HINCKLEY NATIONAL RAIL FREIGHT INTERCHANGE

Project reference TR050007

Applicant's Comments on Local Impact Reports [Part 3 of 4 LCC]

Document reference: 18.4

Written Statement of Oral Case ISH6 [Appendix C – Plan for A47 link road footway/cycleway design]

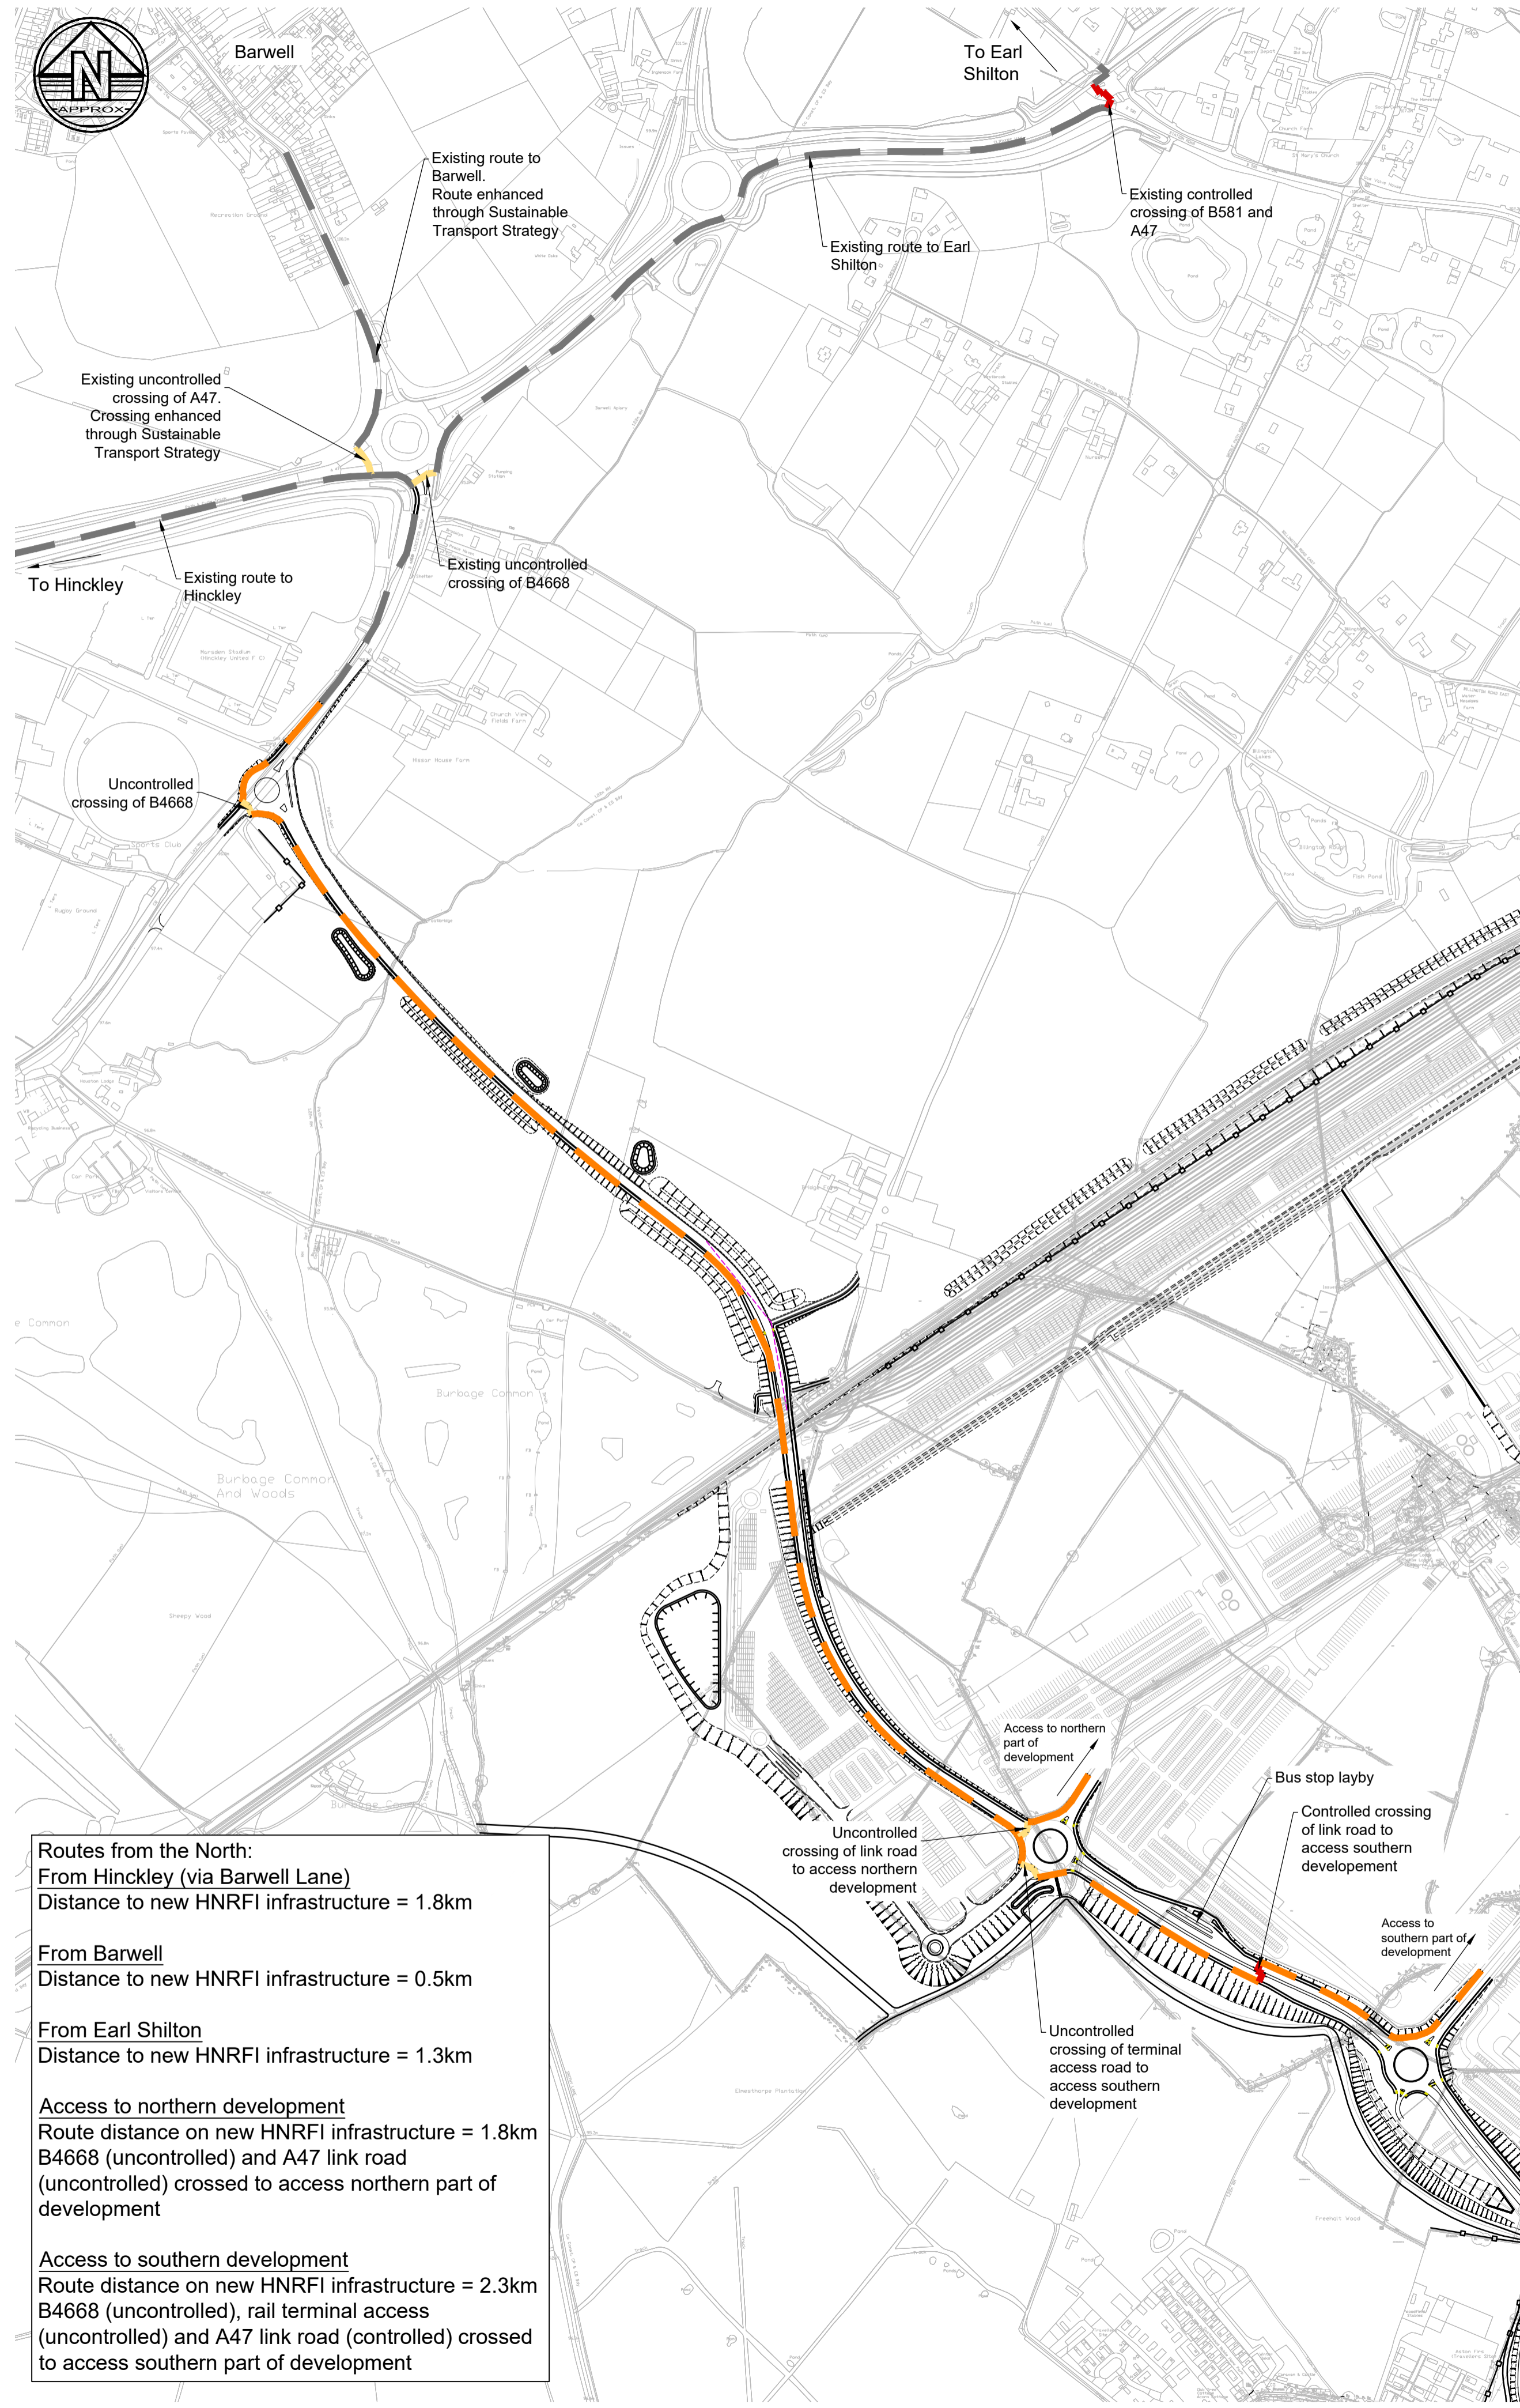
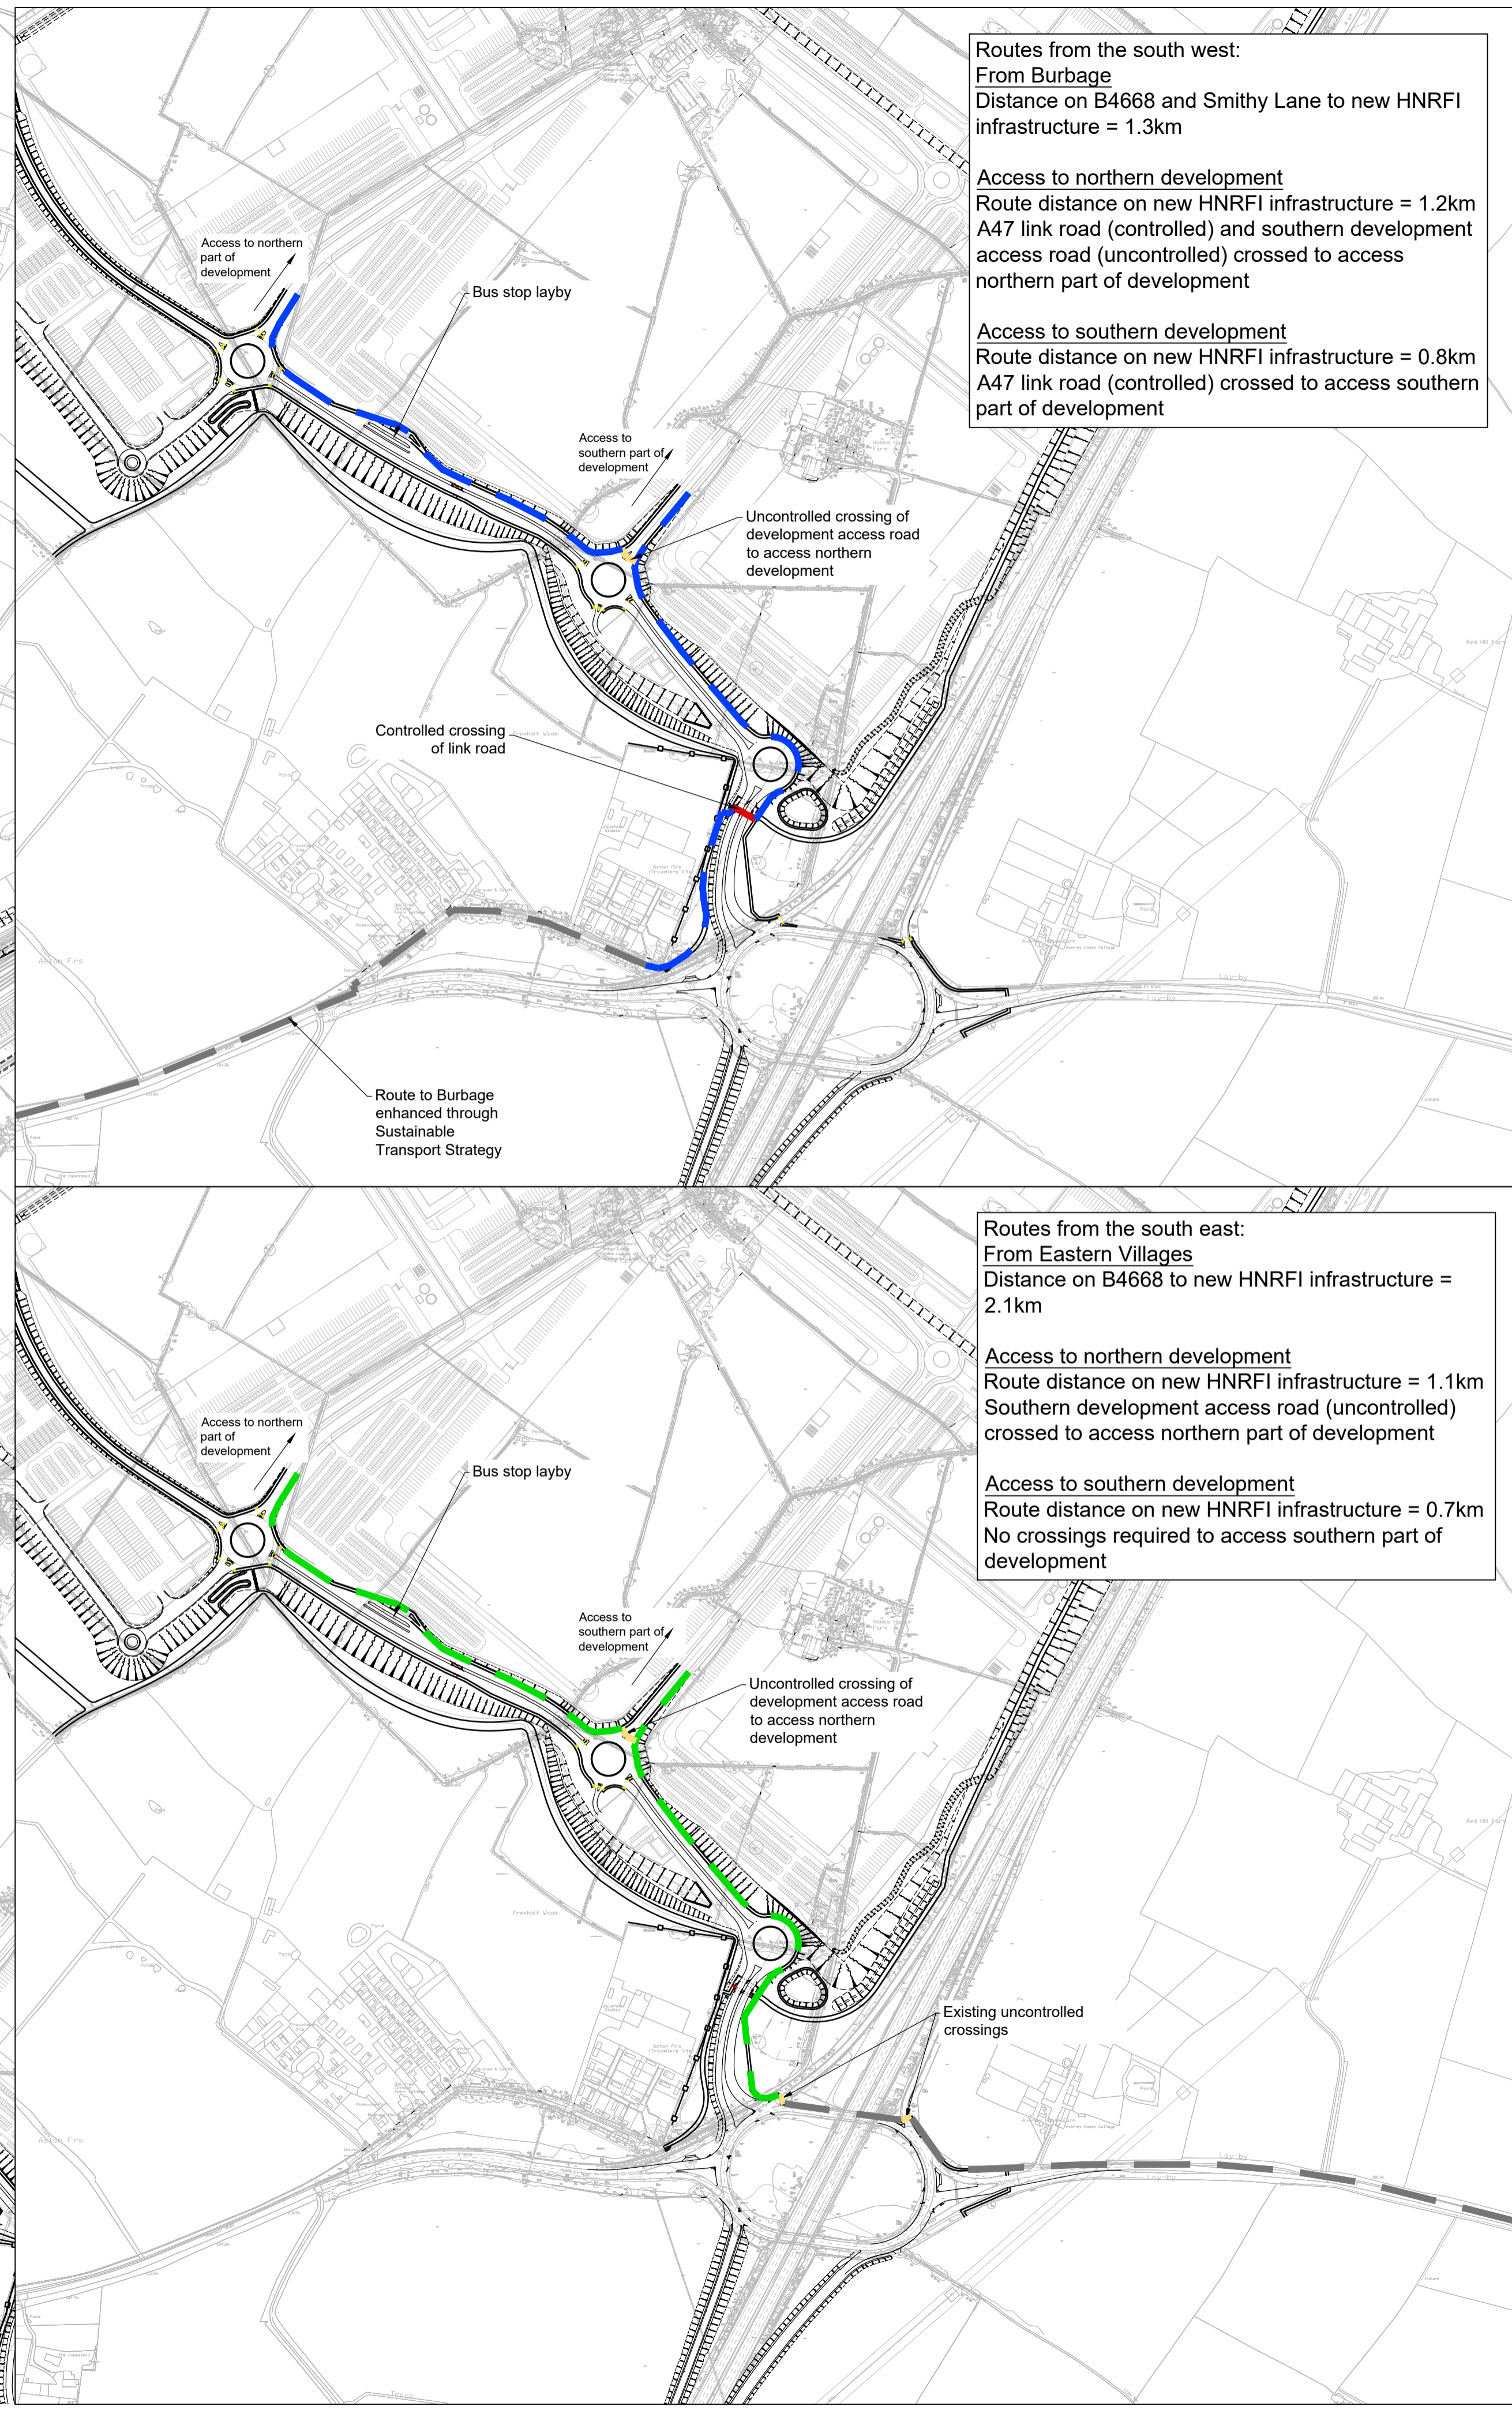
<u>Response Number</u>	<u>Matter</u>	<u>Applicants Response</u>
	Access Infrastructure	
1	<p>LCC notes that there is a discontinuous 3m footway/cycleway requiring pedestrians and cyclists to continually cross the road, not always with designated crossing provision.</p> <p>LCC notes that APP-011 does appear to include for a pegasus crossing and a toucan crossing but questions how these facilities link with footway/cycleway provision. LCC notes that the drawing does not include for connections to existing provision on the B4668 Leicester Road, creating gaps in pedestrian and cycle provision for employees drawn from the villages of Barwell, Earl Shilton and Elmesthorpe.</p>	<p>The Applicant has requested meetings to discuss Design specific items on the LCC highway, including those raised here, on numerous occasions, most recently by email on 13/10/23.</p> <p>It is correct that there are 3m wide footway/cycleways along the length of the A47 link road with a pegasus crossing proposed at the southern end to provide a crossing point for the diverted bridleway and a toucan crossing provided in the vicinity of the bus stop proposed on the link road (document reference 2.2D, APP-011). The footway/cycleway provision links with the existing shared footway/cycleway on the northern side of the B4668 (with a connection between existing and proposed facilities noted on 2.2A, APP-008). An uncontrolled crossing point is provided at the splitter island to the west of the proposed roundabout on the B4668.</p>

<u>Response Number</u>	<u>Matter</u>	<u>Applicants Response</u>
		<p>In order to demonstrate the pedestrian and cycle provision more clearly, the applicant proposes to produce a series of larger scale plans for consultation with the Local Highway Authority’s design team for Deadline 3. The same information can be seen by zooming in on the pdf versions previously supplied.</p>
2	<p>LCC states that the proposed design as shown on APP-011 does not appear to include any improvements to walking and cycling provision or any safe controlled crossing points across the existing and proposed slip roads.</p> <p>In addition, LCC state that there are no walking and cycling improvements included to the west to encourage employees from Hinckley and Burbage to walk or cycle to the site.</p>	<p>Discussed with LCC on 13/10/23 for review on linkages over Junction 2.</p> <p>As part of the works to the J2 roundabout it is proposed to incorporate improved crossing points over the existing north facing slip roads and general footway improvements to the J2 circulatory. These improvements are listed as opportunities 10 and 11 in the WCHAR assessment report (document reference: 6.2.8.1, APP-154), and the revised footways including links from J2 to the A47 link road are shown on the highway plans (document reference: 2.2D, APP-011). In order to demonstrate the pedestrian and cycle provision more clearly, the applicant proposes to produce a series of larger scale plans for consultation with the Local Highway Authority’s design team.</p> <p>As there is no footway or cycleway provision on the south side of the junction at present and no connecting walking or cycling route along the south side of the B4669, there are no proposals to provide crossing facilities over the new slip roads.</p>
